#### Response to Planning Application

**From:** Arun District Council Greenspace

**Application ref: BE/16/25/RES**

**Location:** Land at Oldlands Farm Newlands Road Bognor Regis PO22 9NN

DRAWING TITLE
**DETAILED PLANTING PLAN
(Sheet 1 of 2)**

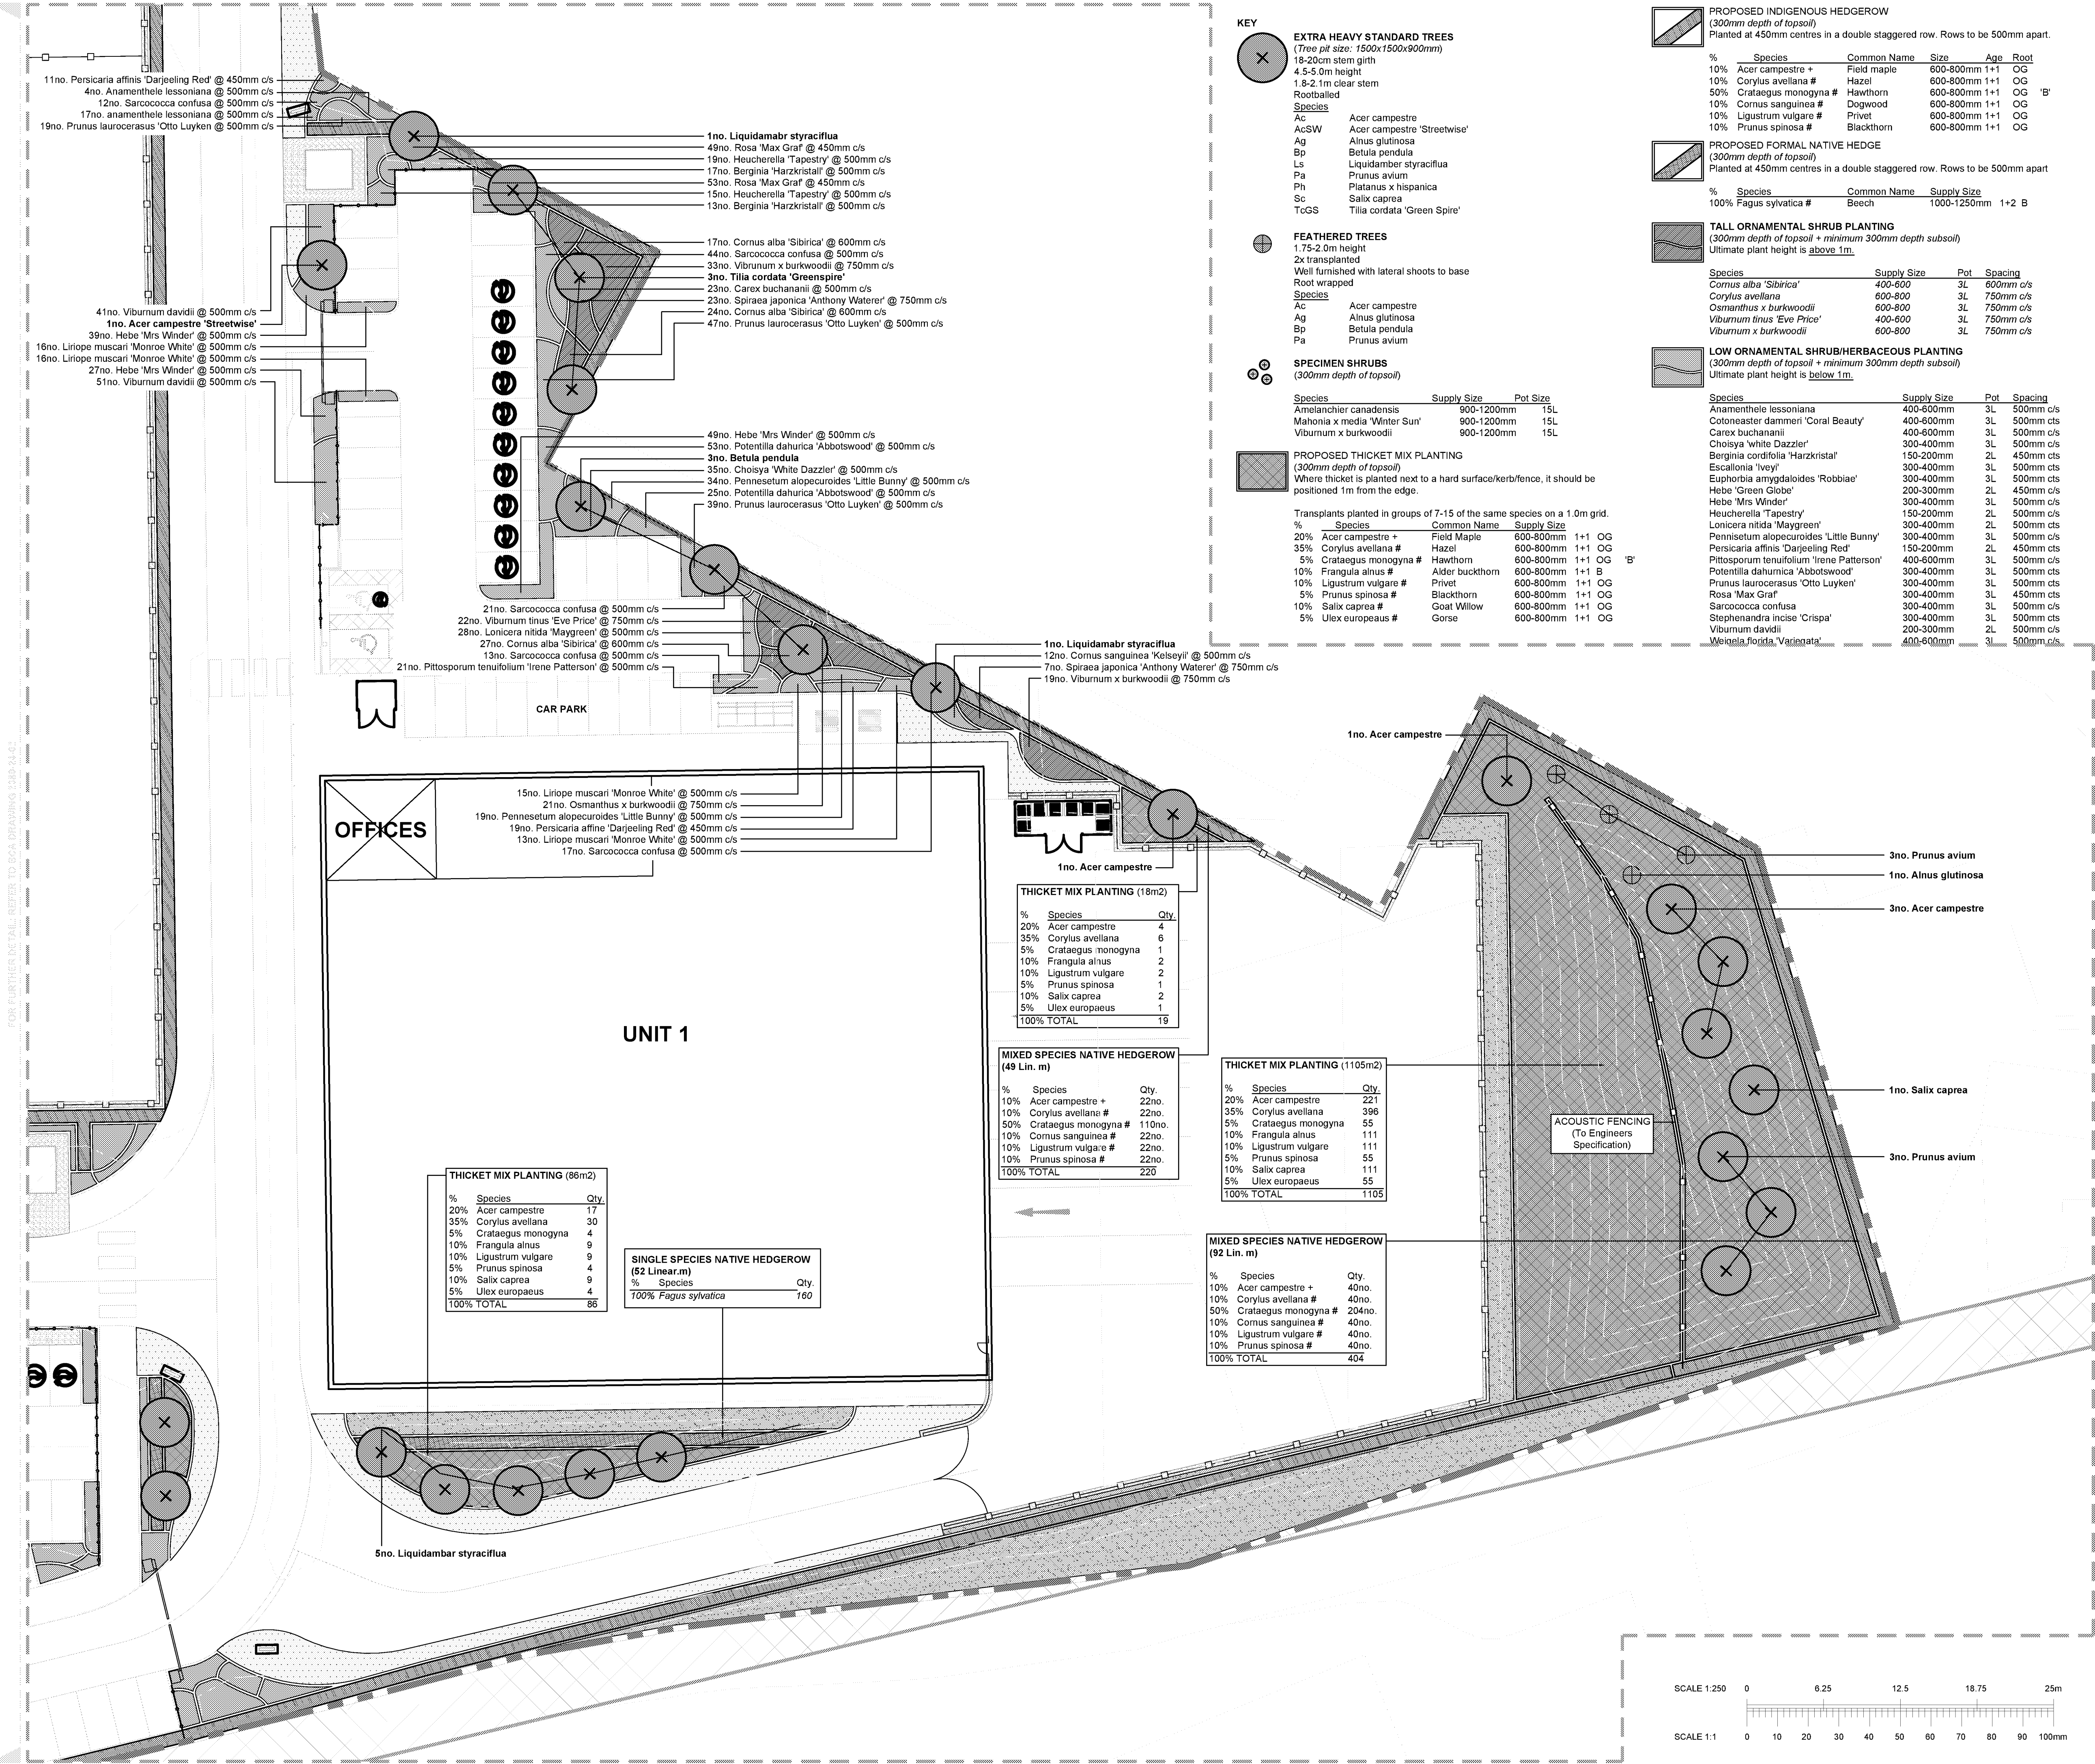
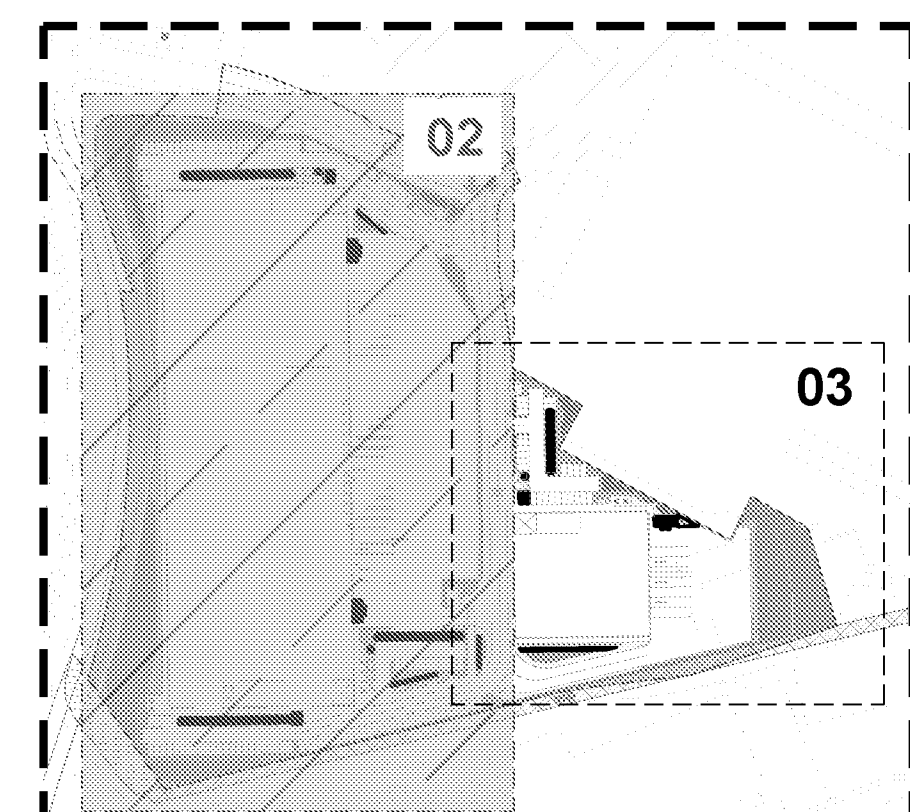
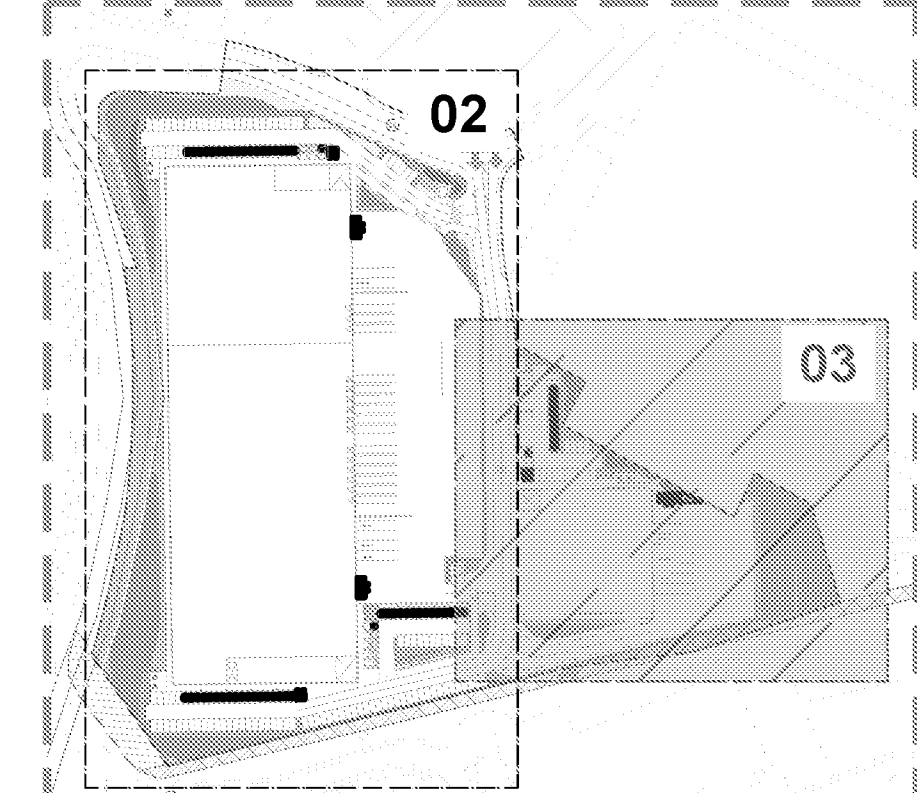
The BE/16/25/RES application now includes superseded landscape detail to include the now included SuDS features and contained within substitute plans Drawings 2380/24-02 Detailed Planting Plan (sheet 1 of 2) Rev **06** and 2380/24-03 Detailed Planting Plan (sheet 2 of 2) Rev **06**.

The landscape detail now incorporates SuDS features within the scheme. The proposed landscaping would be largely unaffected by the incorporation of these features. The previously shown 3no trees have now been repositioned within the proposals to accommodate the 3m offset required to the SuDS. These are 1no Acer campestre 'Streetwise' to the west of the northern SuDS area and 2no Tilia cordata 'Greenspire' to the north of the northern SuDS area – (for avoidance of doubt this amend has now been provided in plan form)
